# Tween Bridge Solar Farm

## 8.14 Change Request Document

**Document Reference: 8.14**

**June 2026**

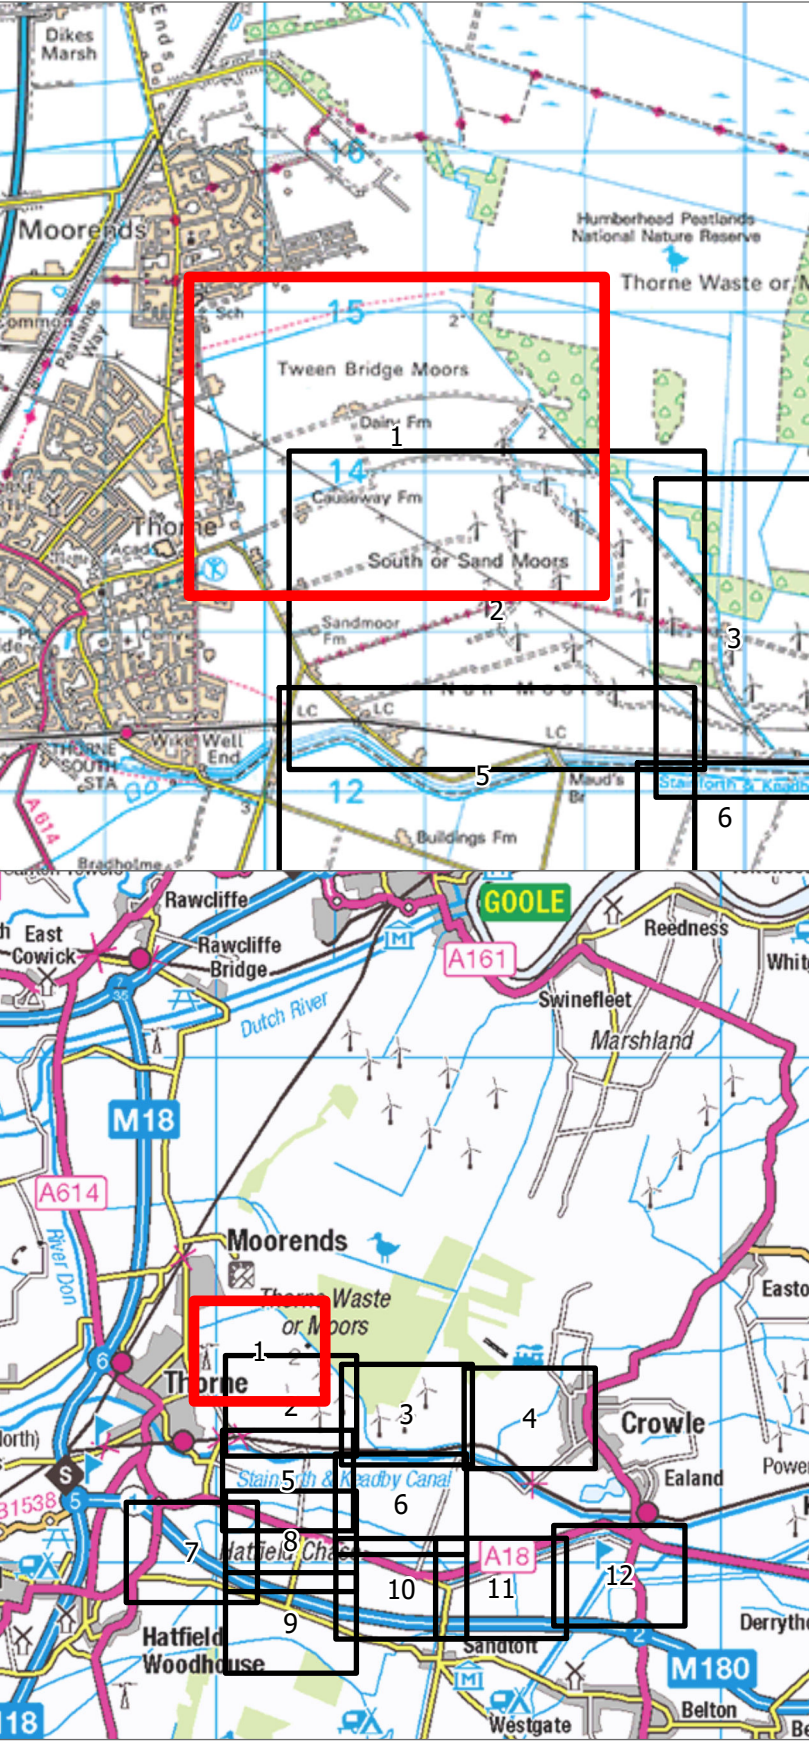
### 2.1. Parcels 1/A, 1/B, 1/C, 1/D, 3/C, 3/D, and 3/E

- 2.1.4. Accordingly, the Applicant proposes that these parcels be removed from the extent of land subject to compulsory acquisition, temporary possession and works powers under the Draft DCO. The Applicant has made the following changes to application documents to secure this outcome:

- amending the **Land Plans [Document Reference 2.2 Revision 3]** to show the parcels of common land in grey accompanied by the following description "Special Category Land – Common Land: not subject to Compulsory Acquisition, Temporary Possession or Works Powers".<sup>1</sup> Minor updates have also been made to the **Statement of Reasons [Document**

**Plot no. on plan:**  
 1E, 2A

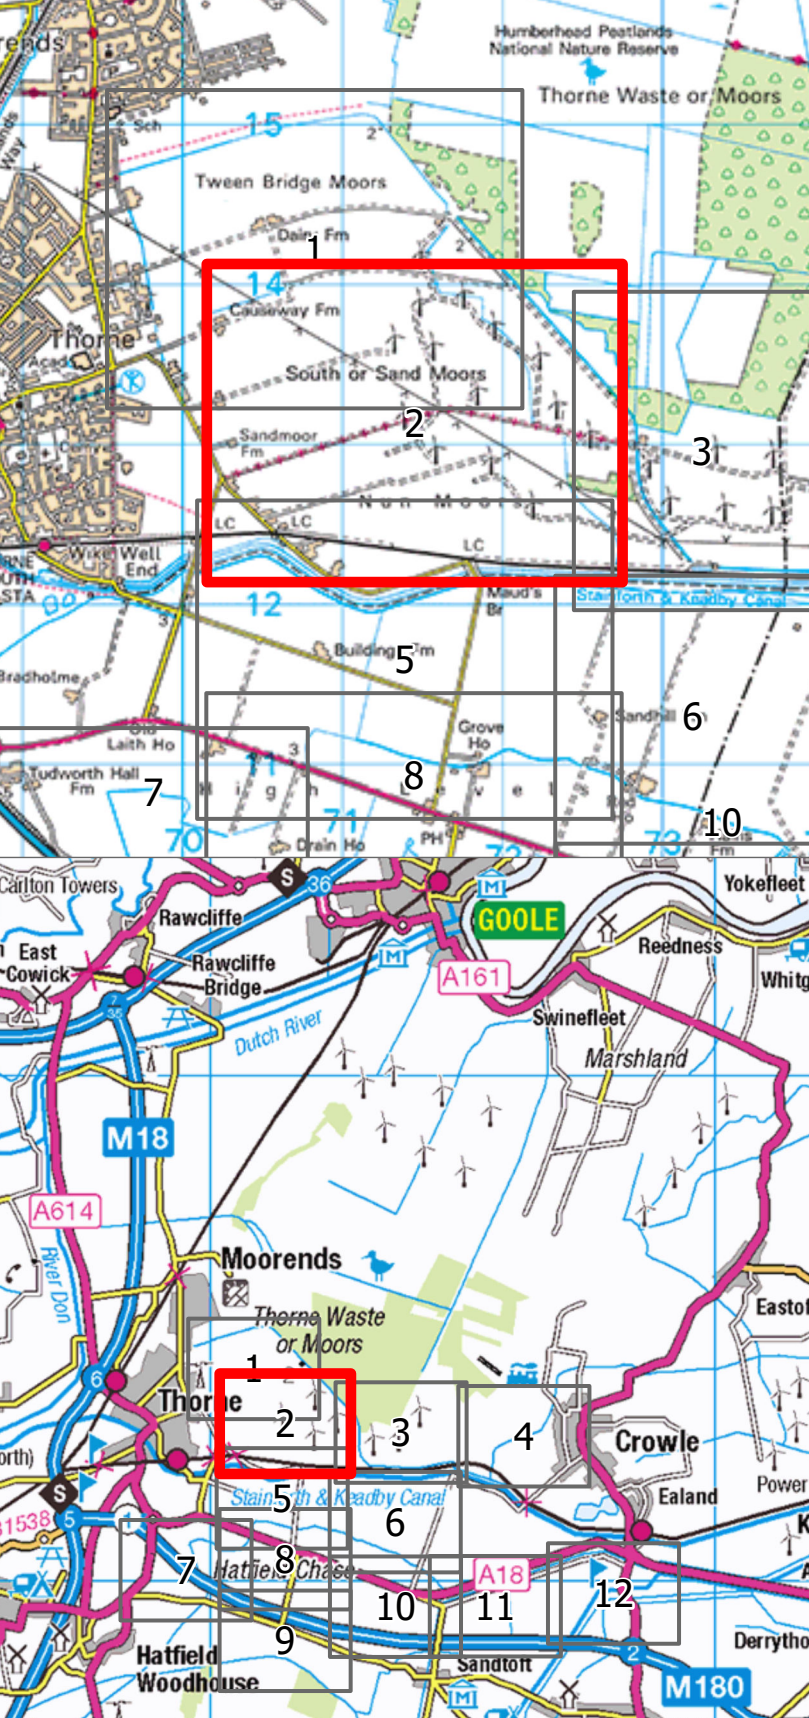
- A minor modification to the proposed permissive path route so that it would avoid encroaching upon parcel 2/A and remain wholly within the limits of parcel 2/16. This would avoid any interaction between the proposed permissive path route and common land, therefore addressing the secondary consenting challenges under the 2006 Act (or otherwise) which would arise from fencing the route as Natural England have suggested;

- Amendment to ES Figure 2.2a, ES Figure 2.2b and ES Figure 6.4 Landscape and Visual Mitigation Strategy [**Document Reference 6.4.6.4 Revision 3**] to identify a minor modification to the proposed permissive path route through mitigation parcel M1(A), so that the route would avoid any interface with parcel 2/A (which is common land), and to clarify that the remainder of the route would incorporate fencing;

- Amending the Land Plans to identify this land as a new parcel (2/B), shown coloured grey to indicate that the land is not subject to compulsory acquisition, temporary possession or works powers. This enables a clear distinction to be drawn between this parcel and parcel 2/A, which is (as noted above) to be retained for habitat creation (Work No. 3);
